A303 Sparkford – Ilchester dualling project

To: Examining Inspector, PINS,

From Sarah Bucks, Chair, South Somerset Bridleways Association

19th May 2019

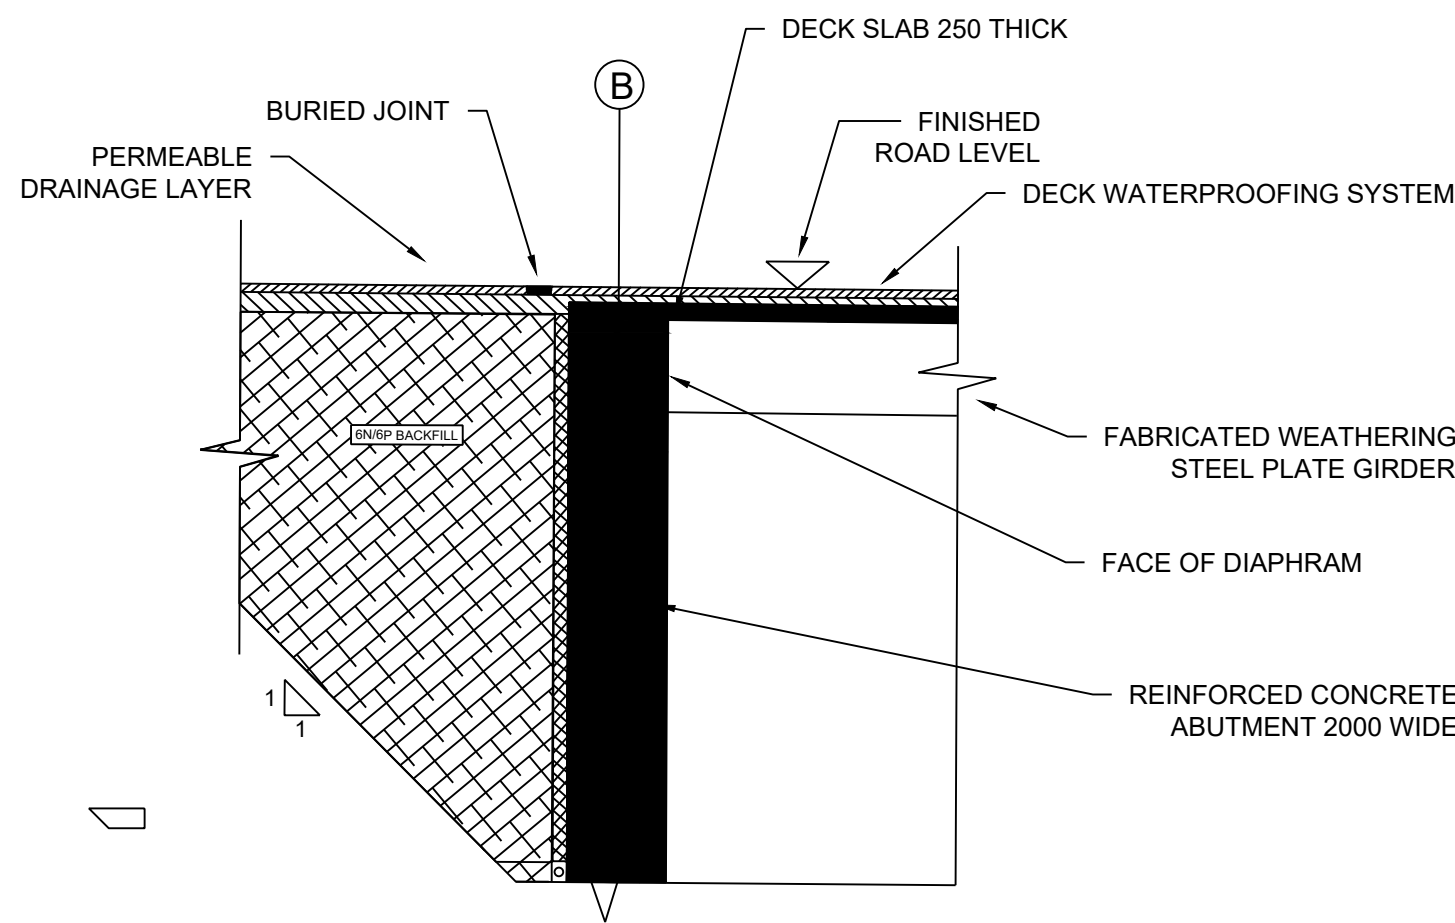
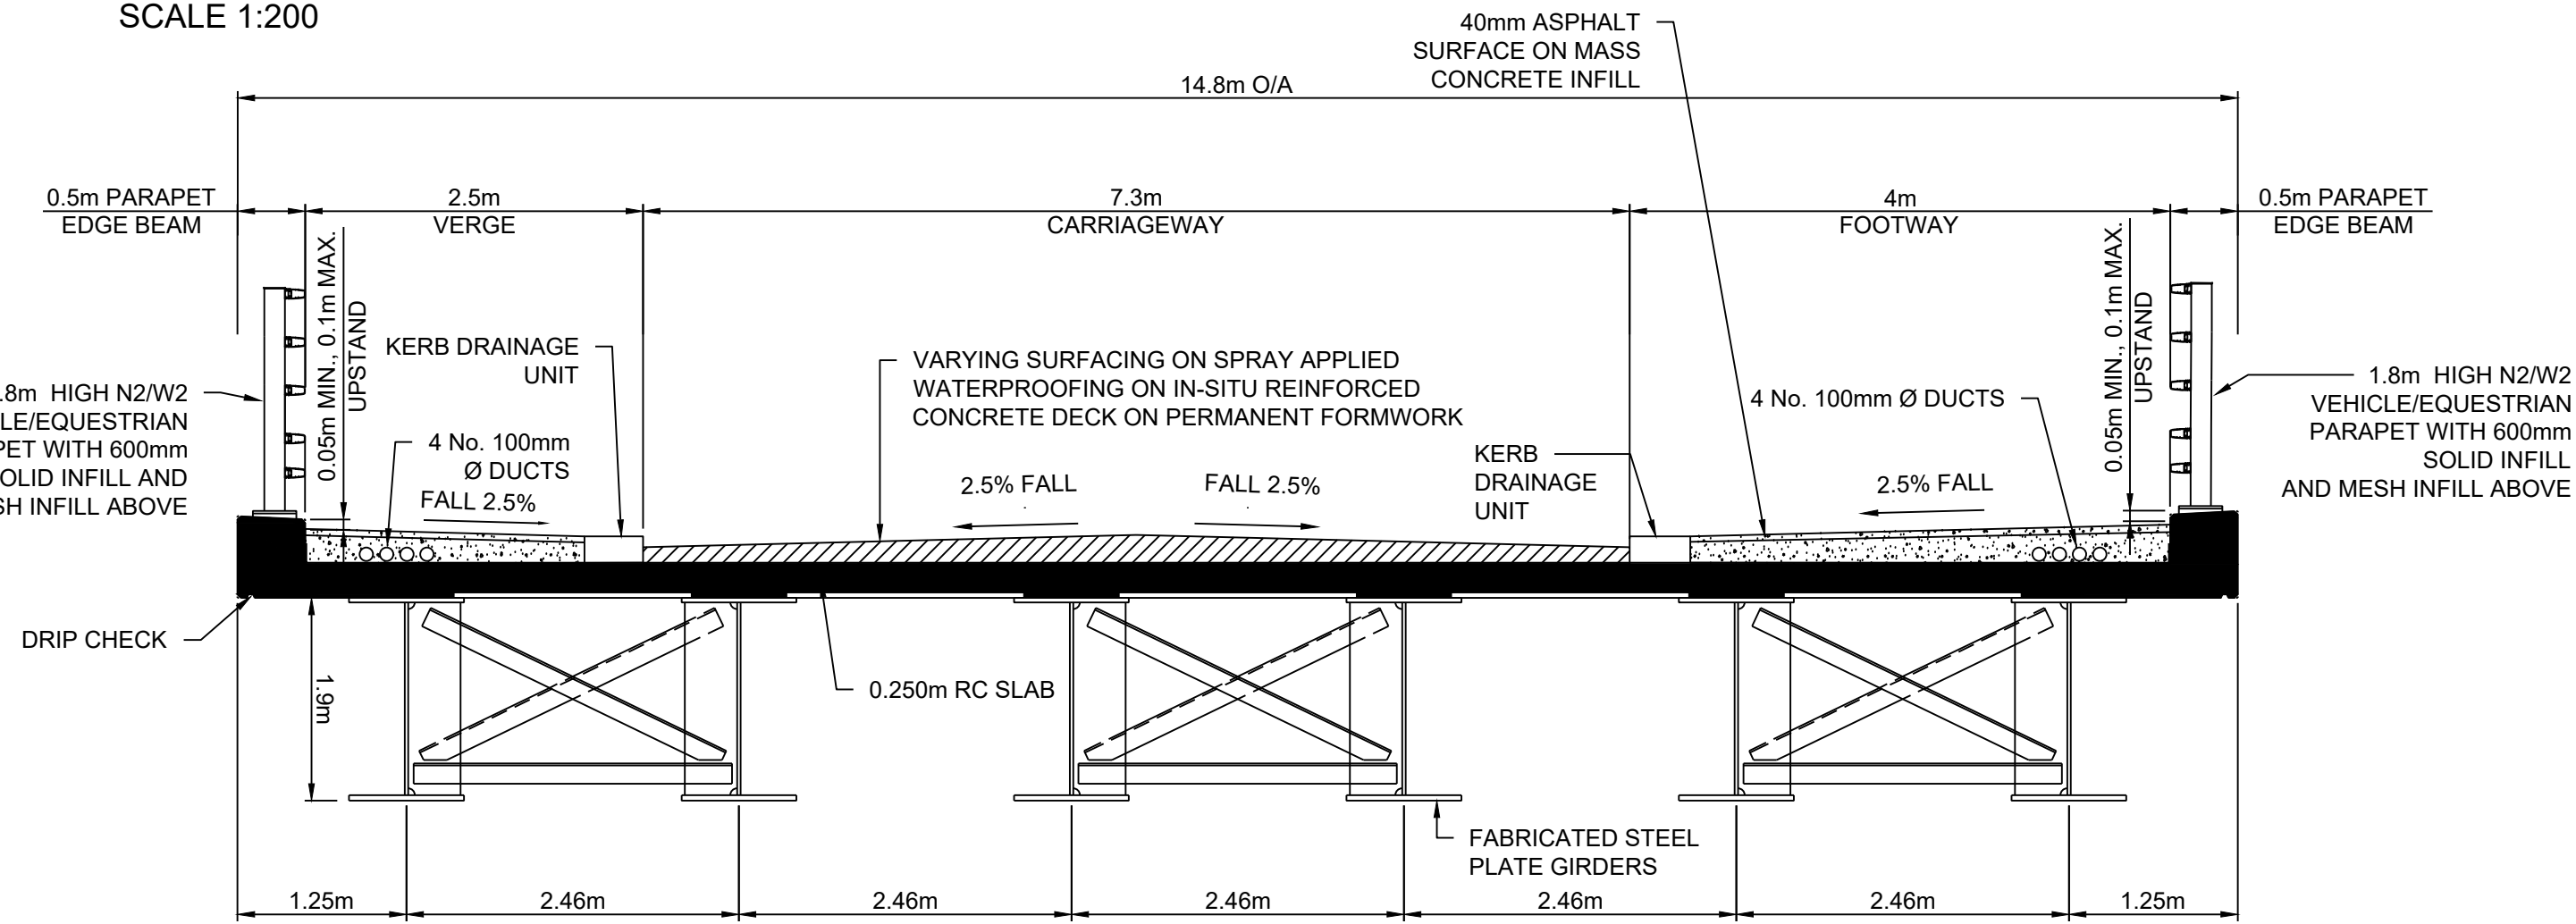
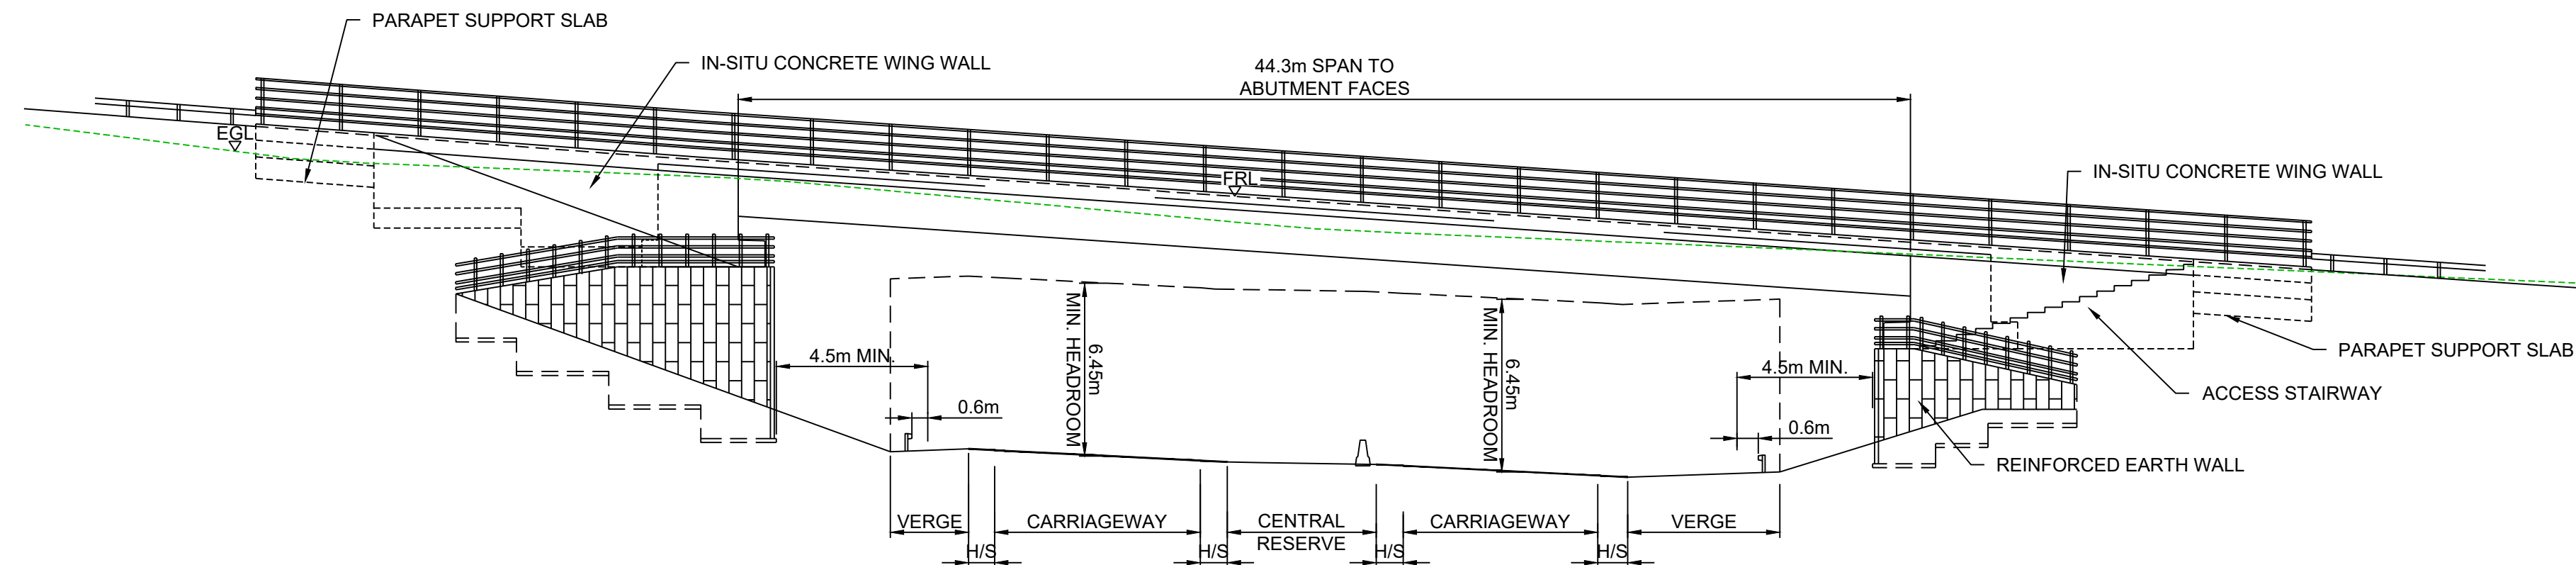
Elevation drawings submitted for both the Hazlegrove tunnel and Stert Hill overbridge (elevation drawings produced July 2018) exclude equestrian routes. They comprise 2.5 metre verge, 7.3 metre vehicular carriageway and a 4 metre wide footpath. We were told that there would be NMU routes at these two locations, yet the elevation drawings deny this. Assuming that these elevation drawings will be part of the tender documents, will NMU routes be built, or only footpaths? The proposal states, schedule 3, part 11, that there will be bridleways dedicated alongside the carriageways on both of these crossings, (Stert Hill crossing AV to AS, and the tunnel BX to BQ to BH to BG) yet the sectional drawings show only footpaths. Which will be delivered, and what mitigation is there for carriage drivers?

Appendix 2 POTENTIAL LEGACY ISSUES IF ONLY PARTIAL REVOCATION OF 1996 SRO

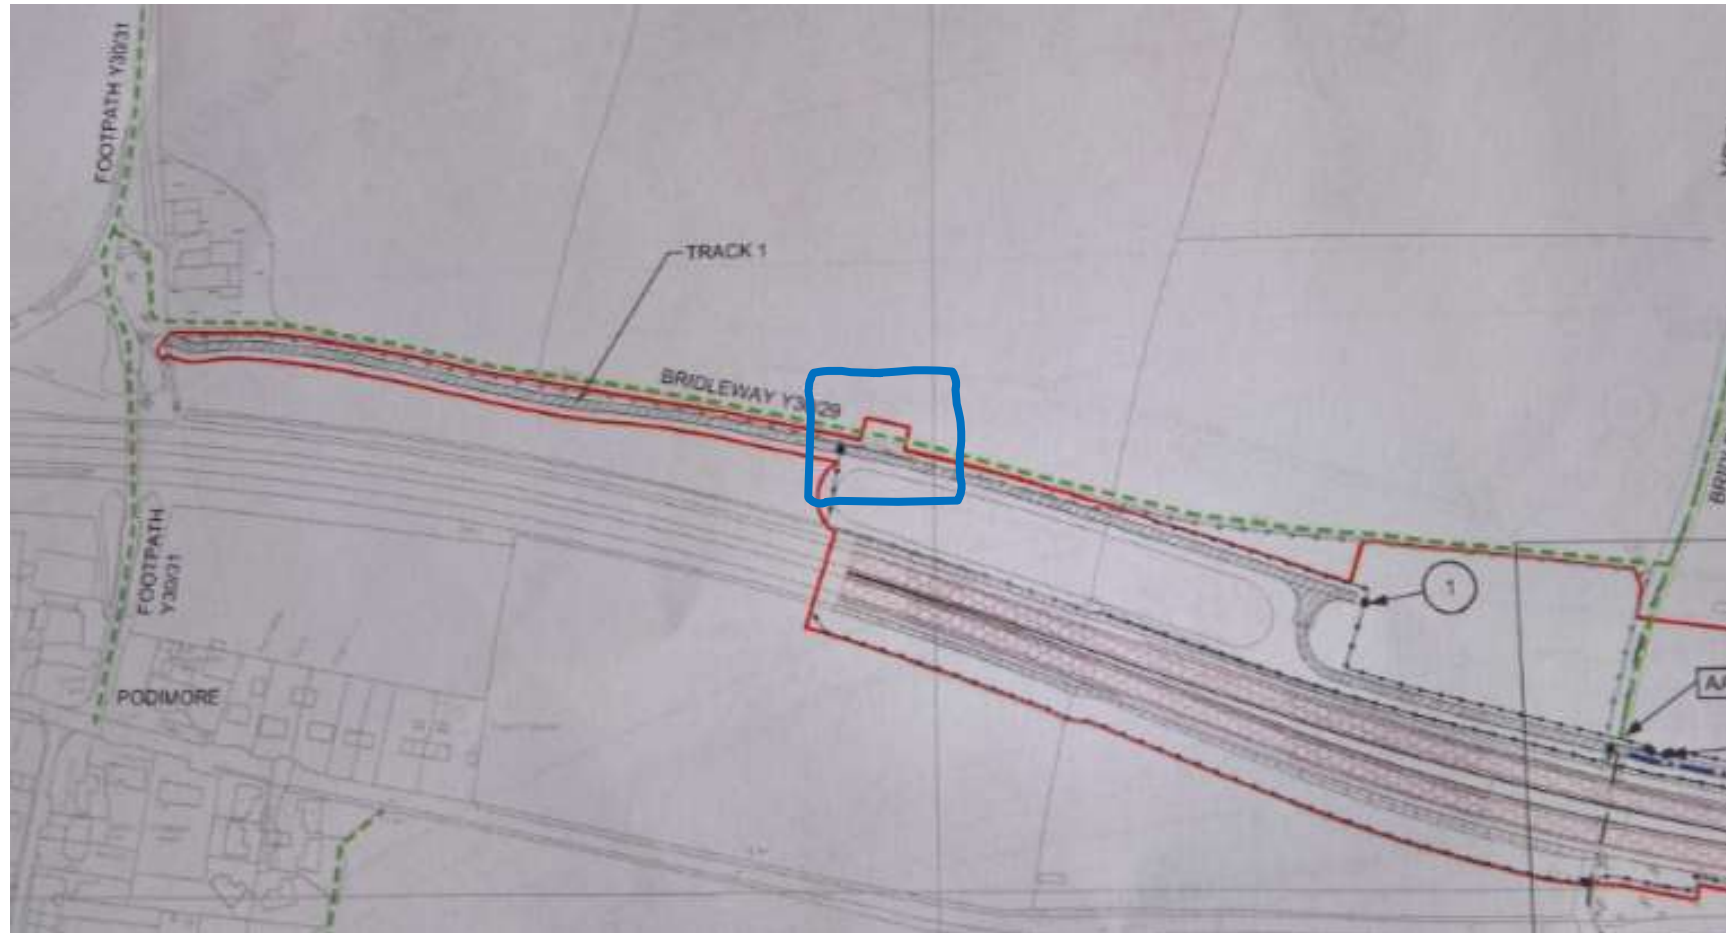
It is extremely discouraging to see that bridleway Y 30/29 which was negotiated in 1996 and shown on the maps for years is going to be revoked without consultation. Please can we be given assurances that there will be some route created in lieu. There is little point in user groups engaging with consultations when there is the possibility of the routes that are agreed being revoked later without consultation.

The land parcels connecting Higher Farm Lane with Eastmead Lane (1/1a, 1/2a, 1/3a and 1/3d) are to be acquired and kept on a permanent basis by HE. Therefore they would have the power to dedicate restricted byway rights along the maintenance track (track 1) between Higher Farm Lane and Eastmead Lane, on the south side of the hedge from the bridleway Y30/29. We understand that the rights over Higher Farm Lane overbridge are being considered for upgrading with the use of HE's Designated Funds. There is a DMMO application to upgrade Eastmead Lane from a bridleway to a restricted byway. Eastmead Lane joins two restricted byways and has all the characteristic of a Restricted Byway, we believe the order should be made on the historical evidence produced. Therefore, in order not to have dead end restricted byway, the new route between Higher Farm Lane and Eastmead Lane, assuming there is going to be one, should be of restricted byway status.
